September 29, 2022

JN 21061

Subject: **Geotechnical Review of Plans**
Proposed Steinborn Residence
8435 S.E. 47th Place
Parcel #3317500040
Mercer Island, Washington

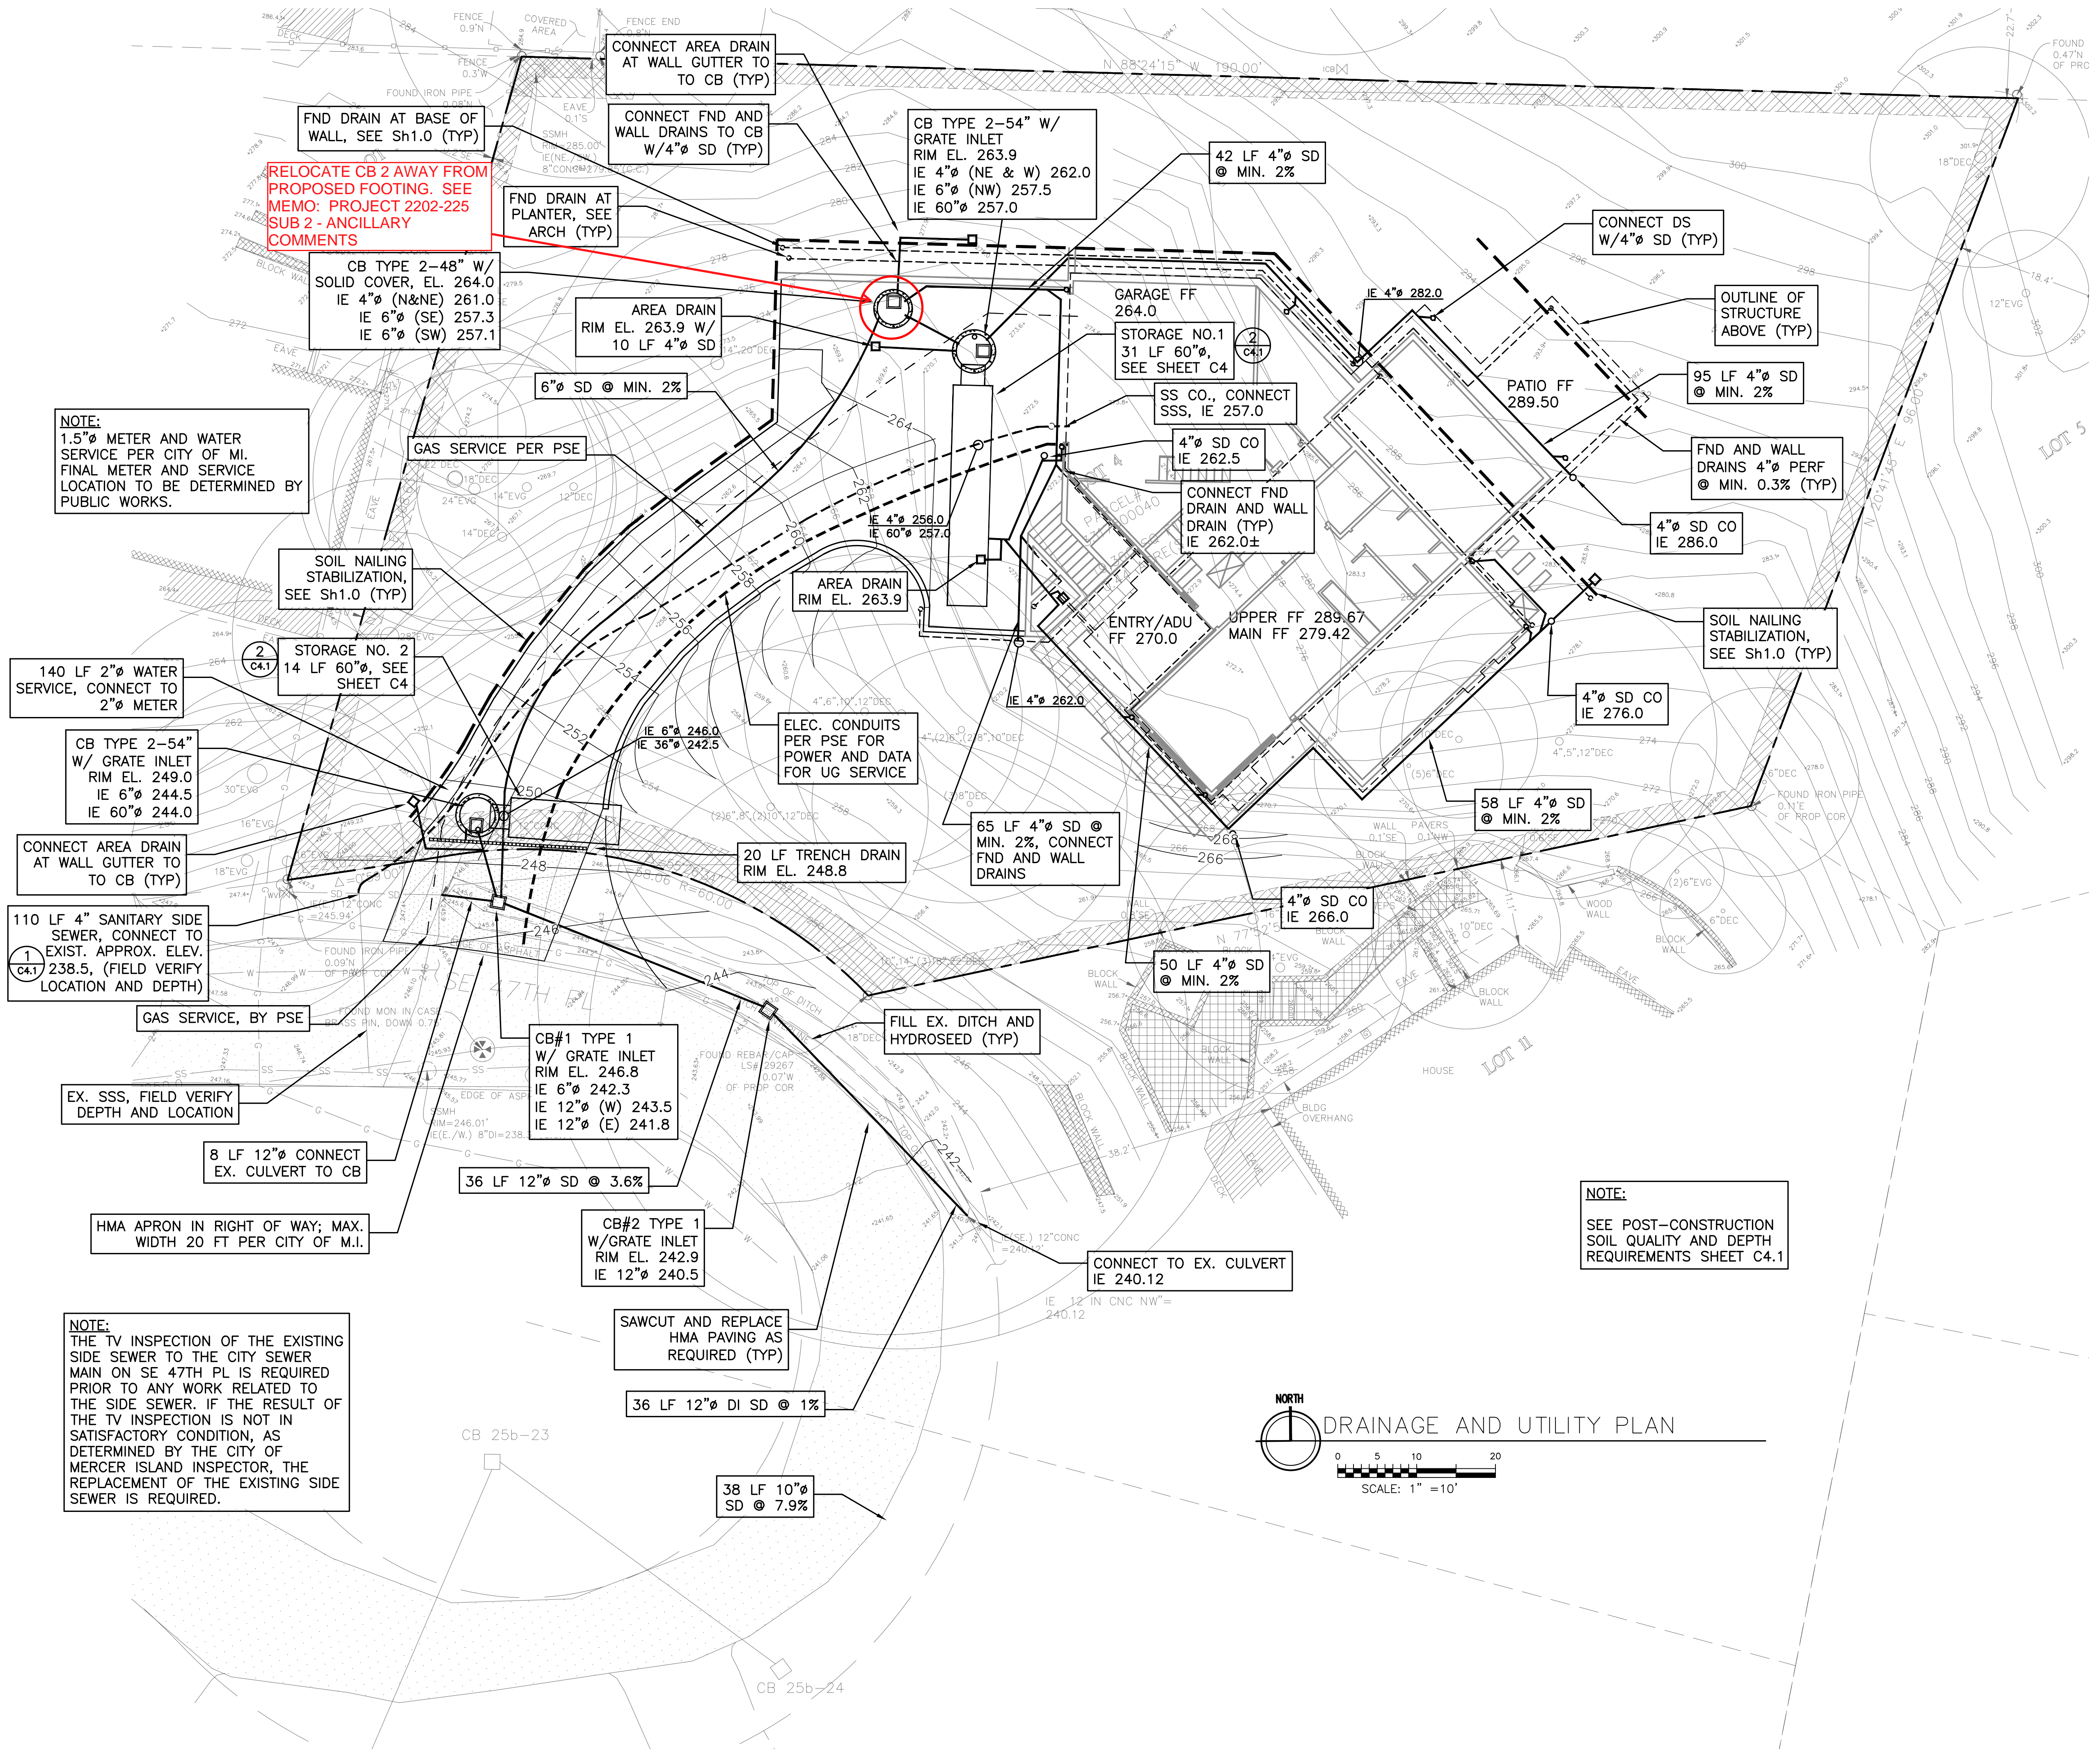
On Sheet C3, the manhole located at the north end of the detention tank will be outside of the footing for the north motorcourt retaining wall. However, we recommend that the backfill around the manhole consists of lean-mix concrete having a minimum one sack (94 pounds) of cement per cubic yard. This will provide appropriate lateral support for the retaining wall's bearing zone. The catch basin/manhole to the west of the detention pipe needs to be moved further south to be outside of the footing and should be backfilled with the same lean mix concrete. We understand that the civil engineer, who is currently unavailable, will make these changes on the drawings.
